CITY OF ALBUQUERQUE

April 4, 2008

Re: Warehouse Addition, 9701 Trumbull Ave. SE, Traffic Circulation Layout
Architect's Stamp dated X-XX-XX (L-20/D012)

SITE PLAN 1" = 20'

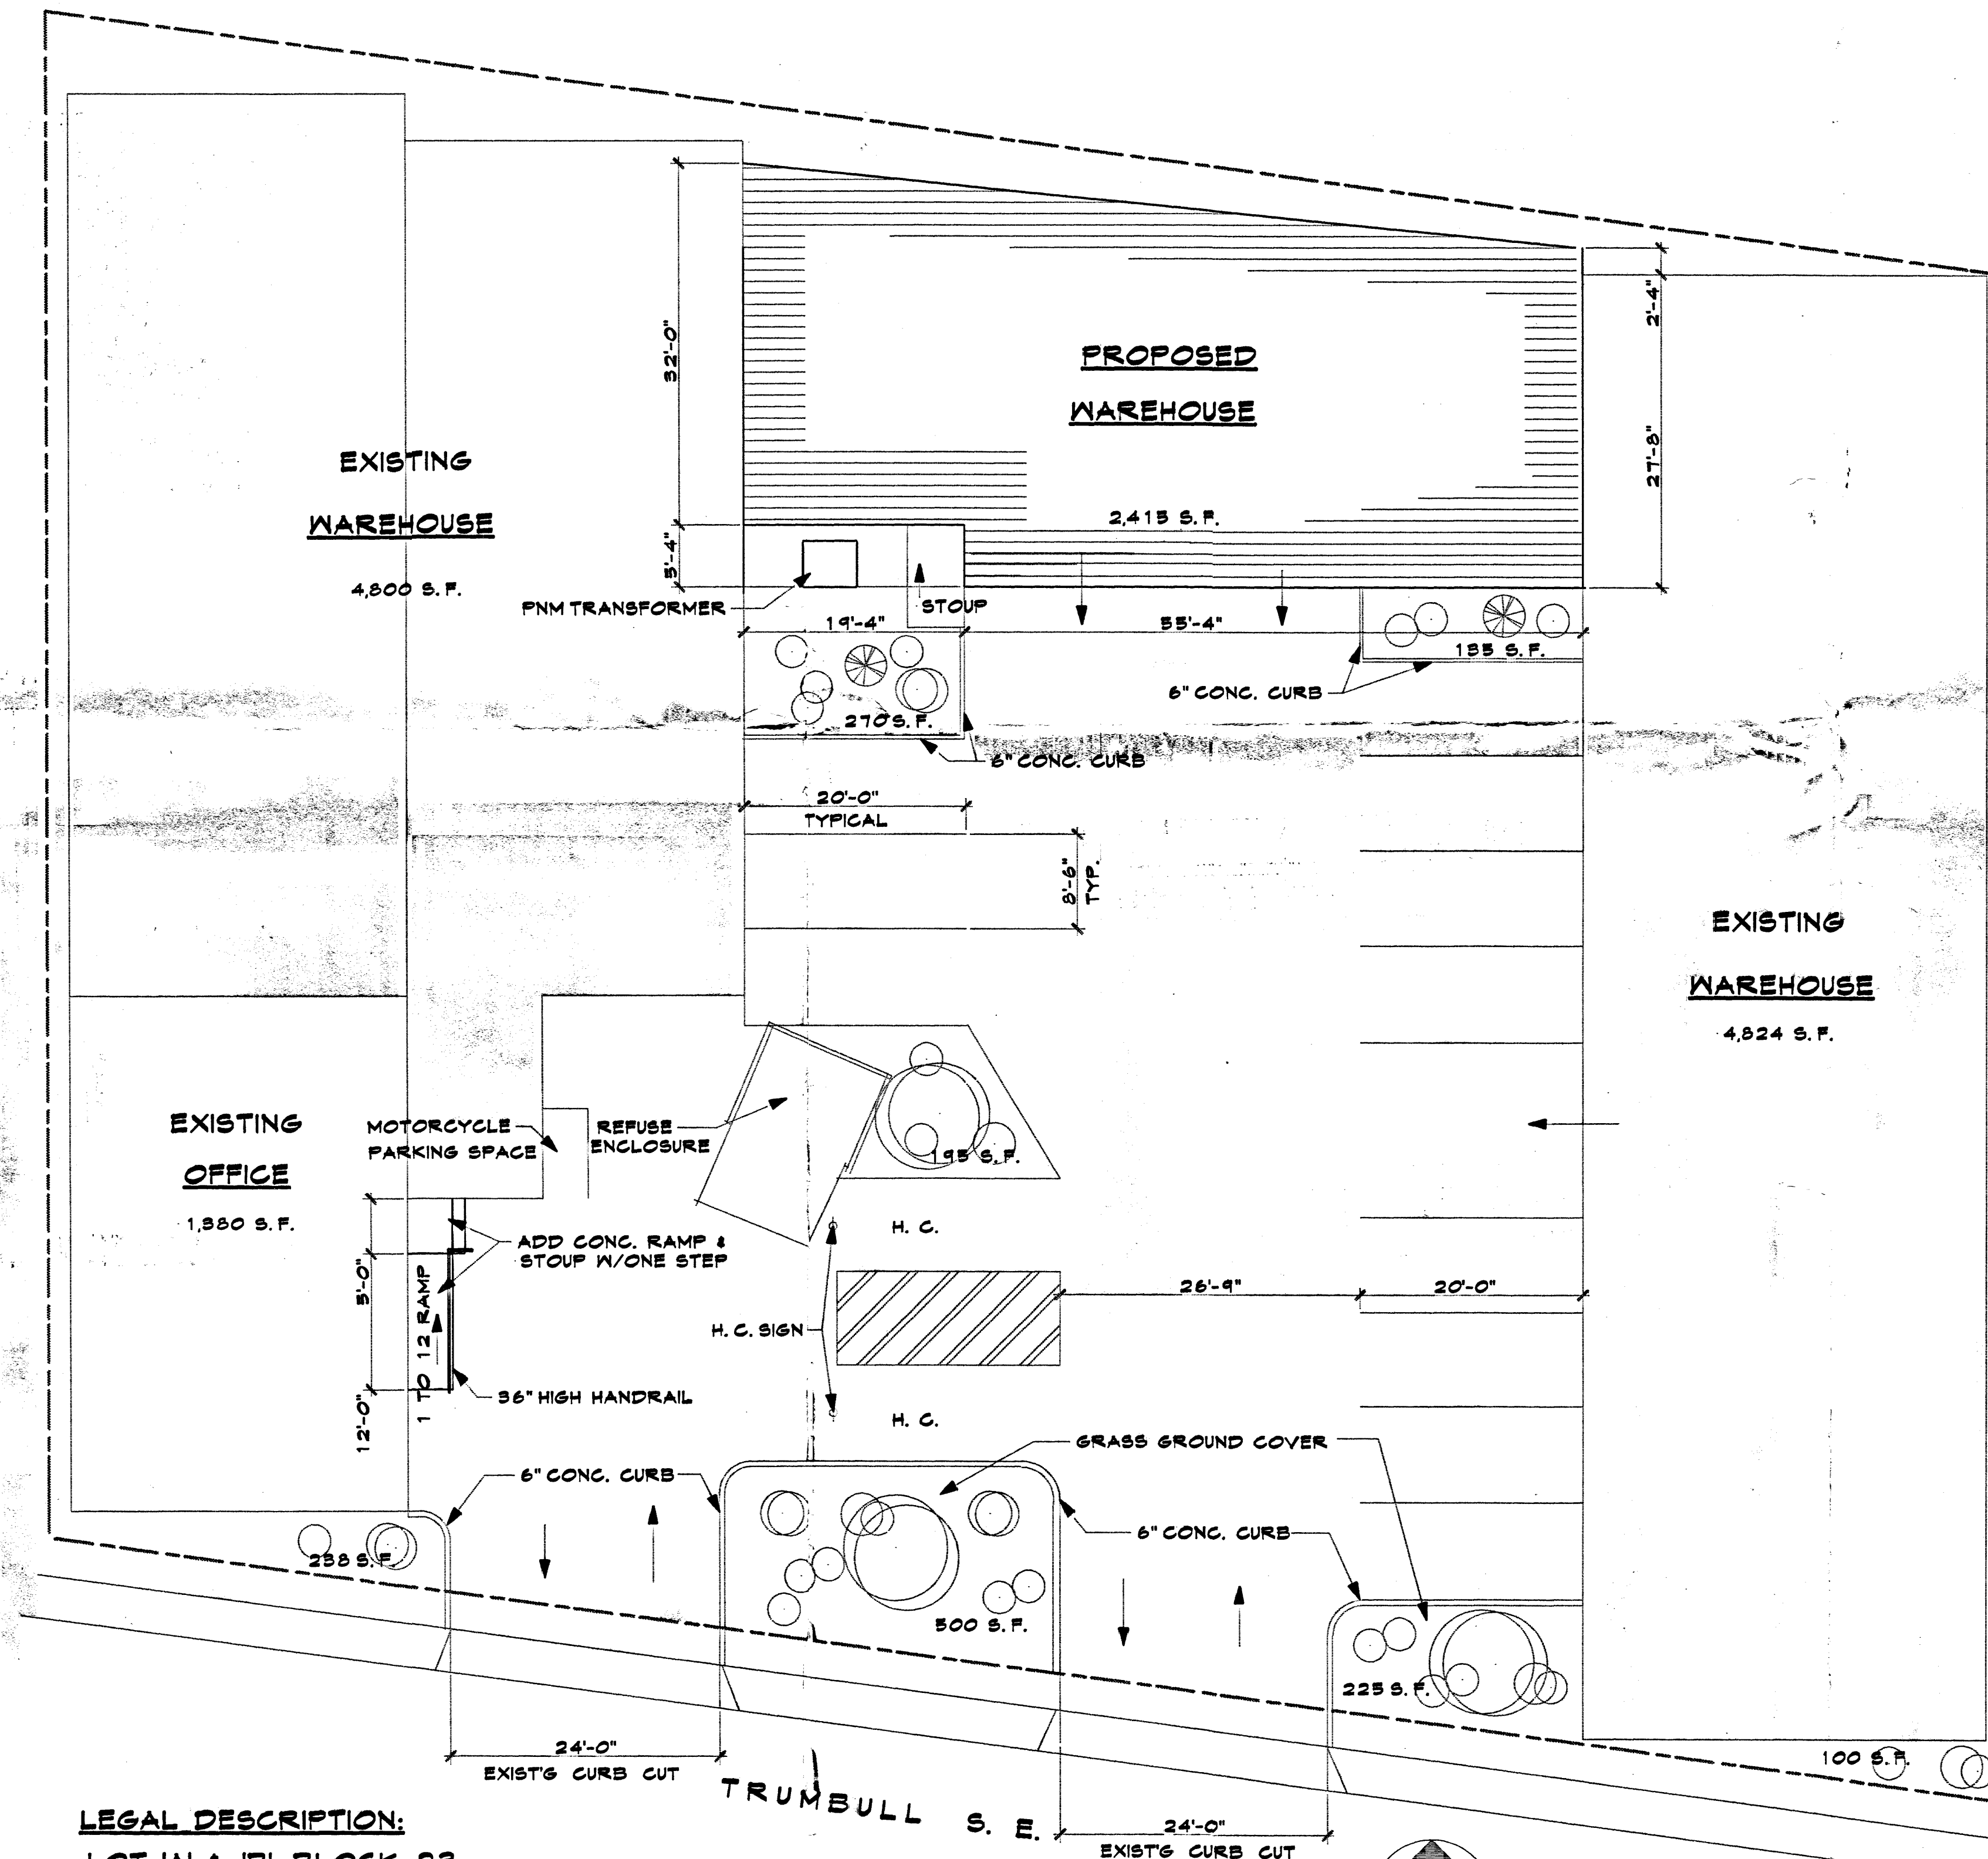
1. The traffic circulation layout must be stamped, signed, and dated by an engineer or architect licensed in the state of New Mexico.
2. Include a vicinity map on the plans.
3. All necessary information must be shown on one plan, labeled Traffic Circulation Layout (TCL)
4. Clarify all existing verses proposed conditions.
5. Show where the loading will occur on the site and clarify the heavy vehicle path.
6. What is the purpose of the western most curb cut?
7. Dimension the handicapped spaces. How will the spaces be protected from the adjacent traffic?
8. Provide the width of the sidewalks.
9. The existing curb cuts must meet current ADA criteria.

✓ Show where loads will occur on the site
- clarify the heavy vehicle path ✓

✓ What is the purpose of
the westernmost curb cut? ~~Interference~~ ✓

✓ Call out width, length for HC spaces -
how will these spaces be protected
from the adjacent traffic? ✓

✓ Call out width of all SCW

exist curb cut must ~~see~~ meet current
ADA criteria

GRADING & DRAINAGE PLAN

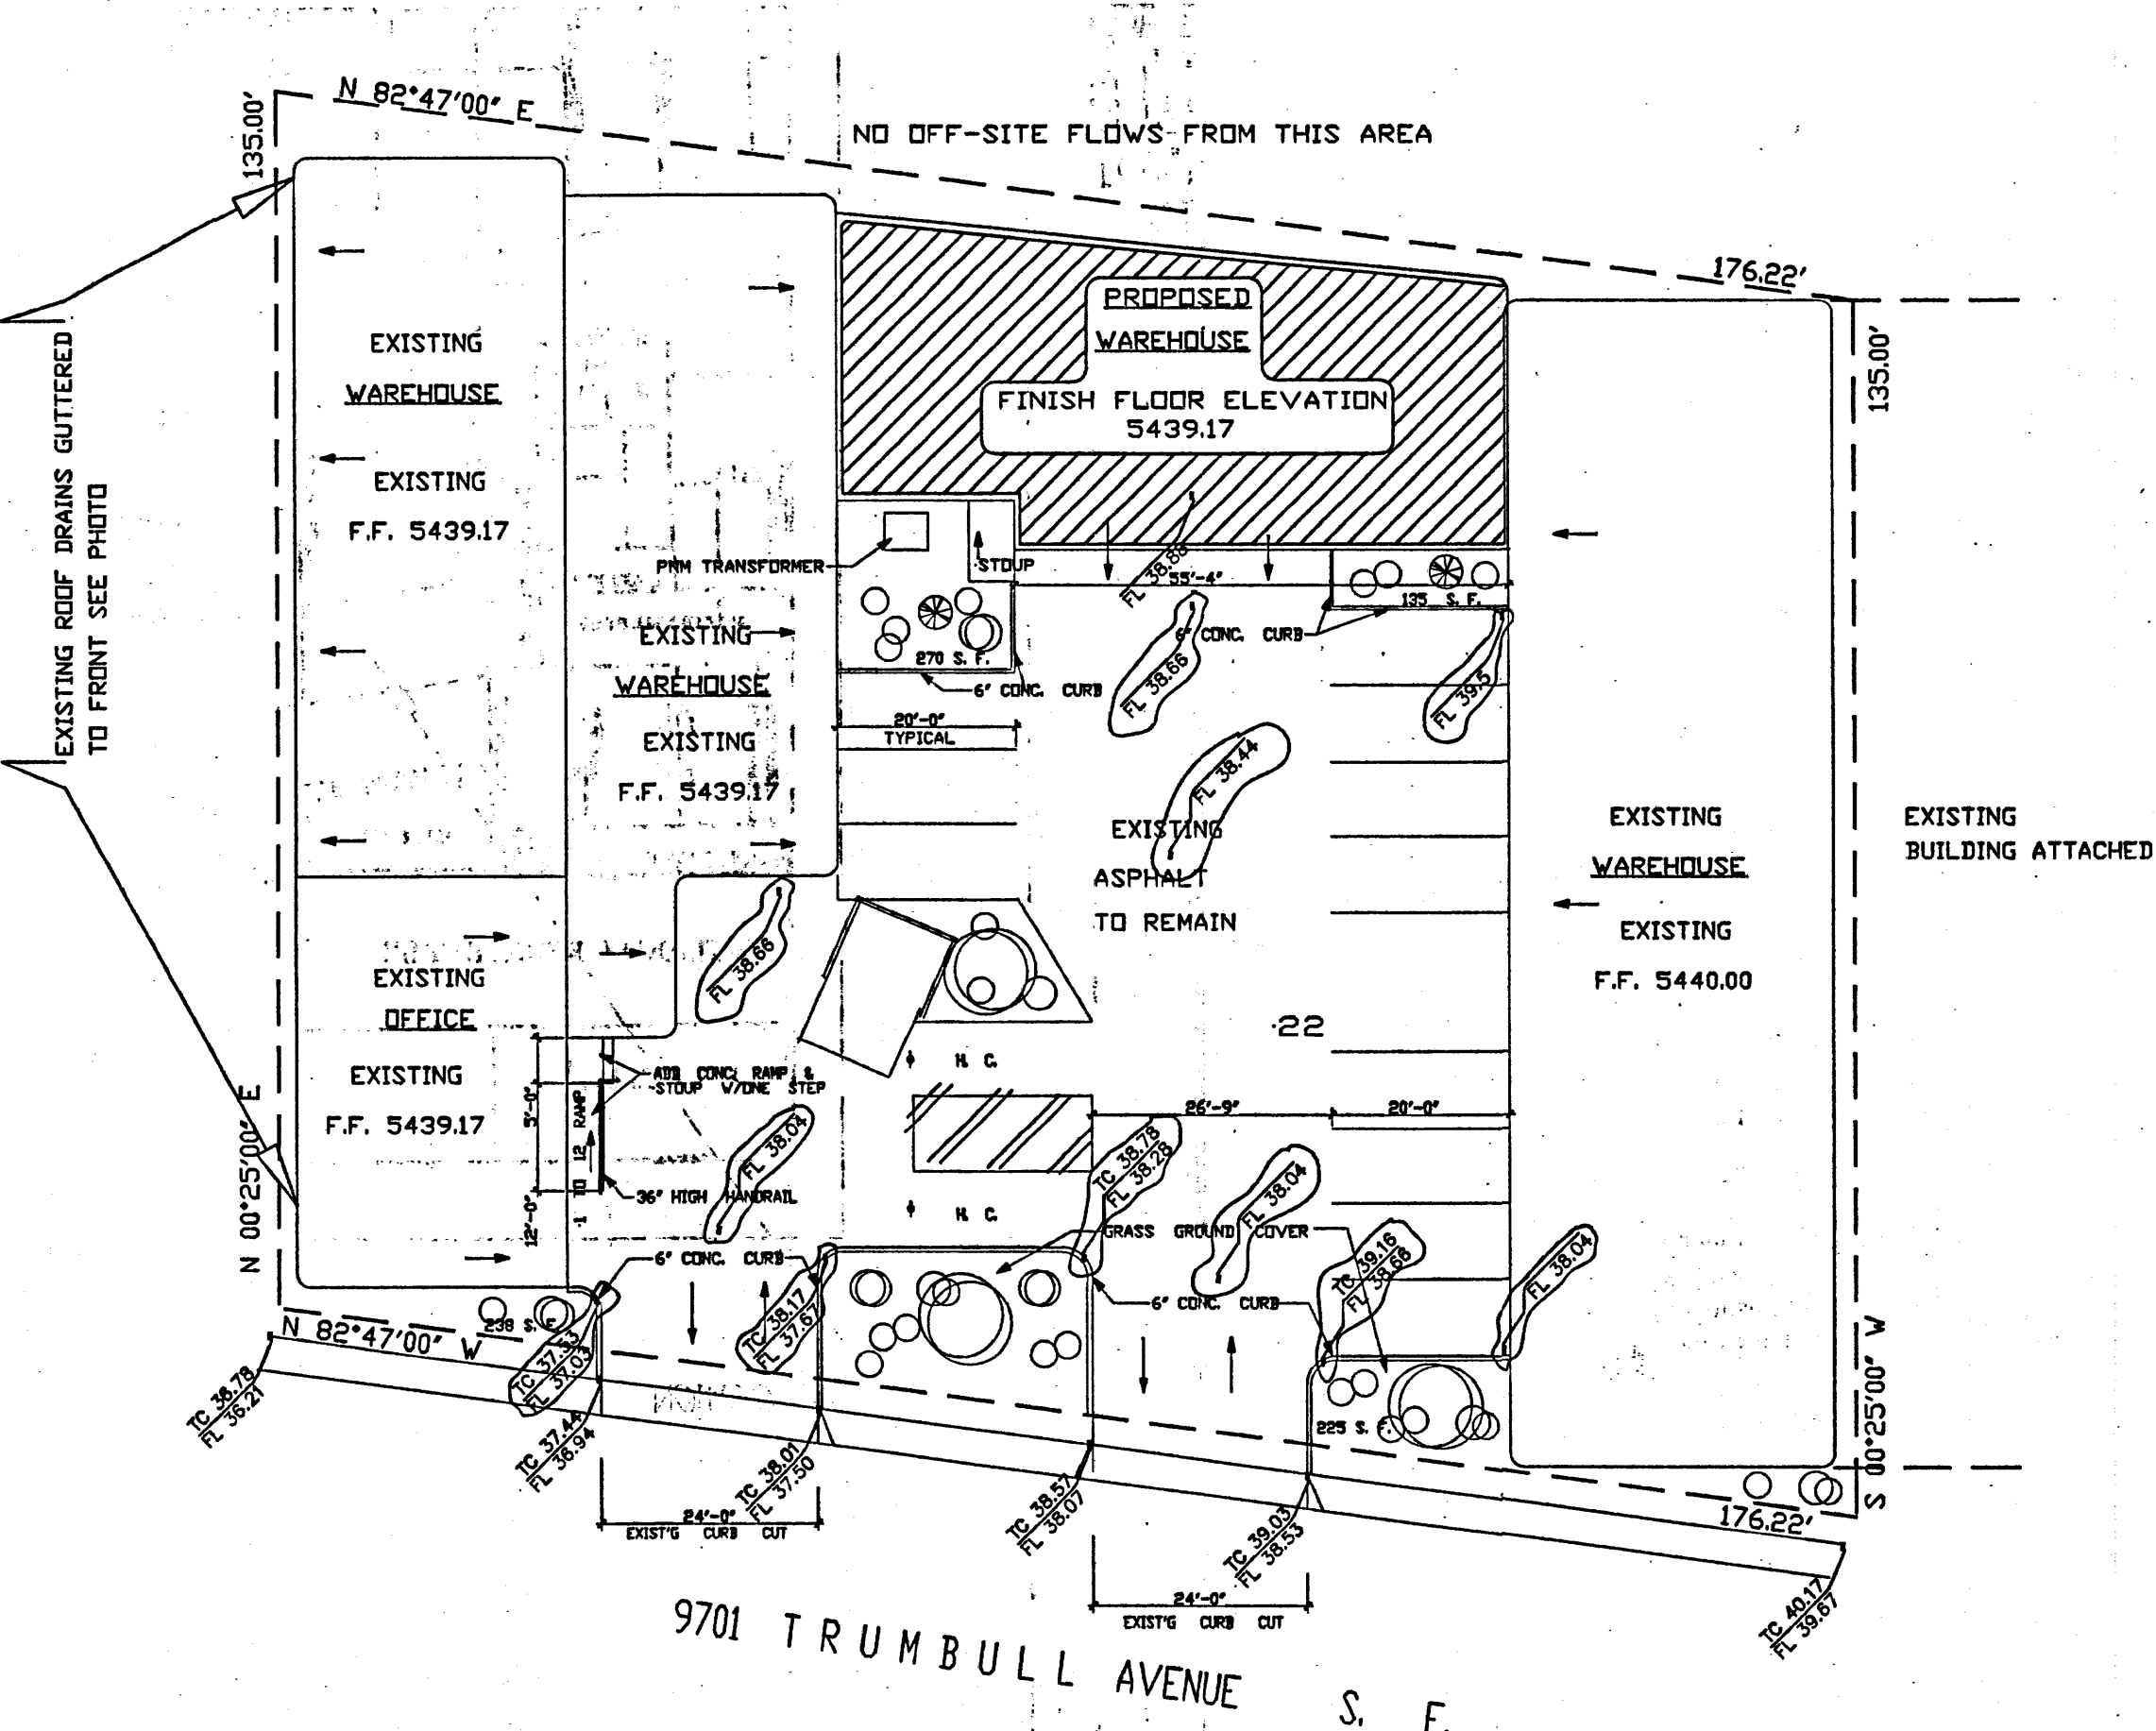
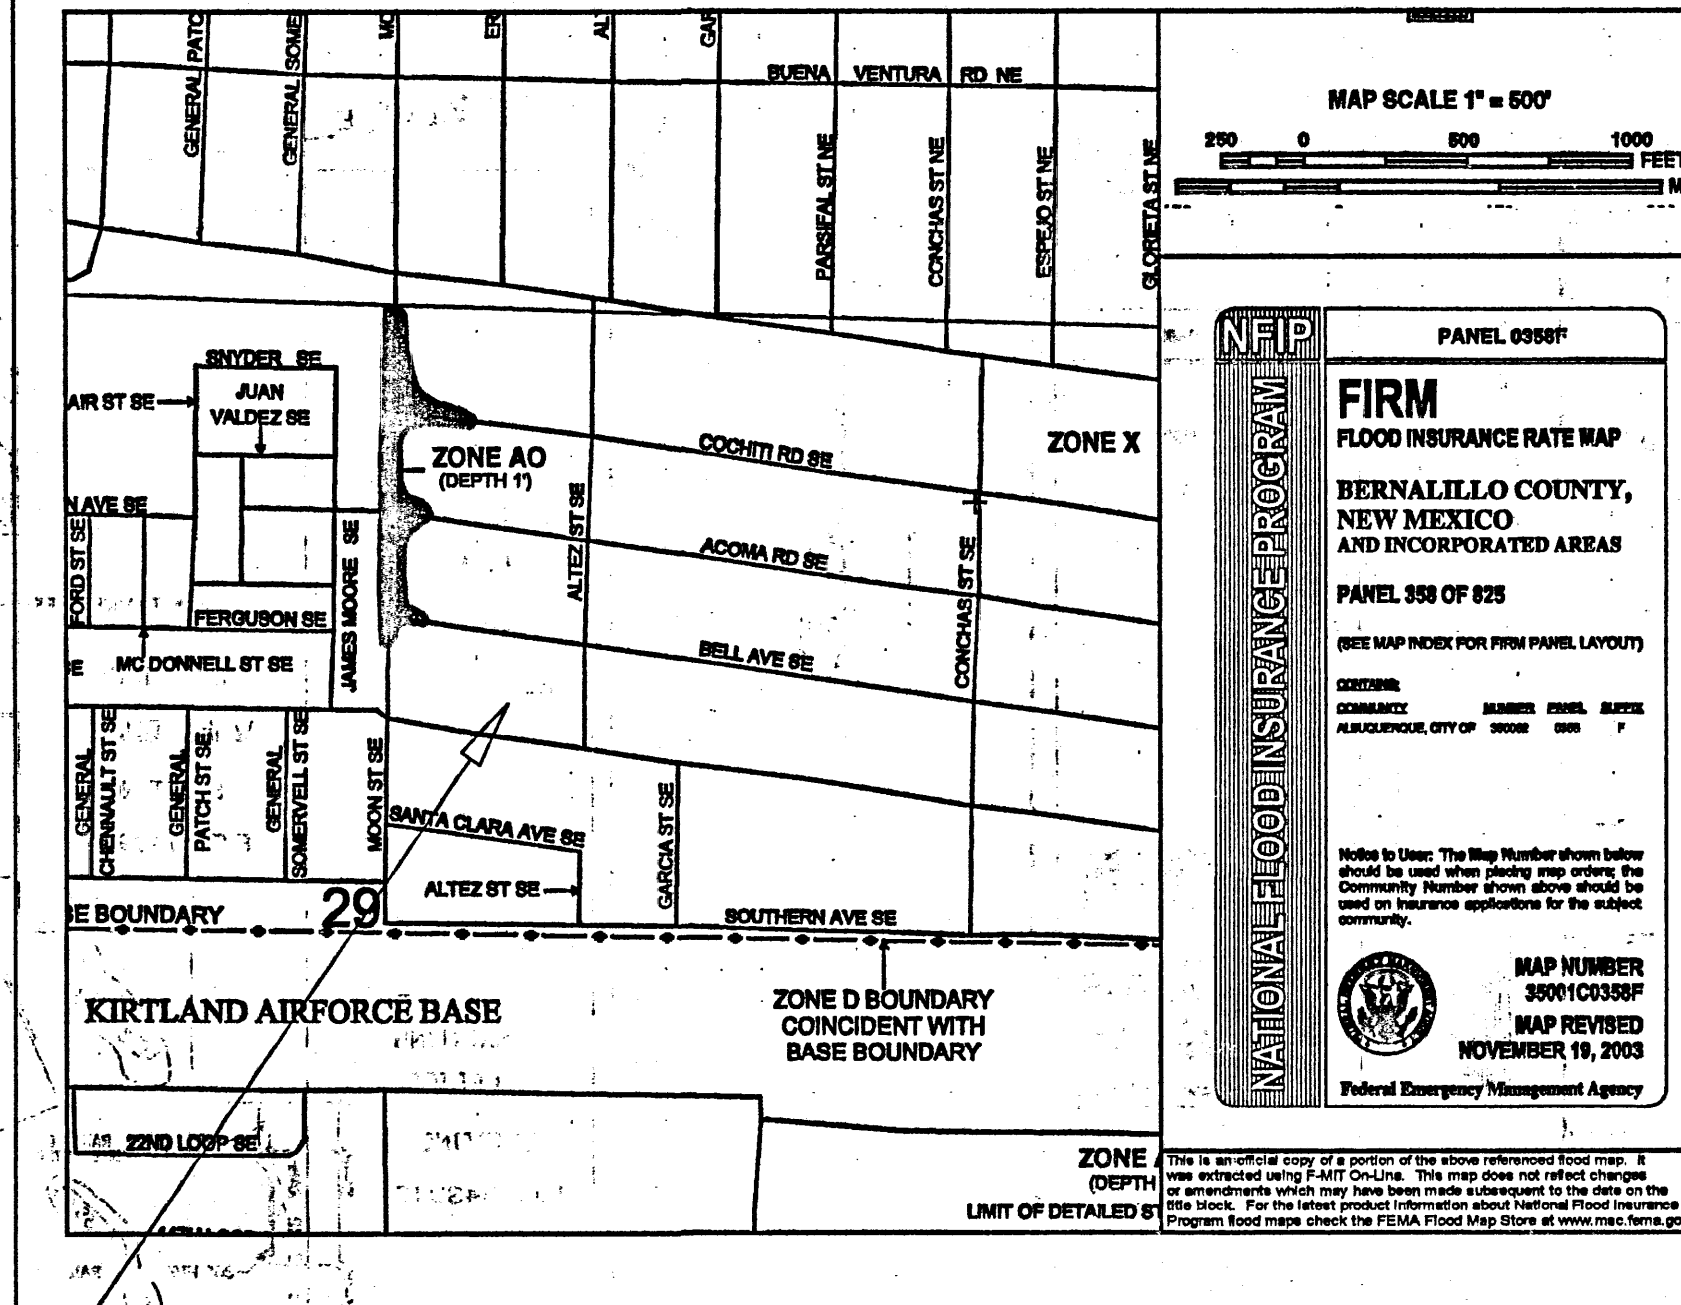
- The proposed building is on the lot line.
- Provide some elevation data in the paved area. Spot elevations near curb corners, near the middle of the entrances back about 20', and one in the middle of the parking area.

1. The proposed building is on the lot line. *A replat has been requested by the Zoning Department. The C.O. will not be issued until the replat has been filed.*
2. Provide some elevation data in the paved area. Spot elevations near curb corners, near middle of the entrances back about 20', and on in the middle of the parking lot. *More spot elevations have been provided on the plan drawing. The extra spot elevations have been clouded for extra clarity.*
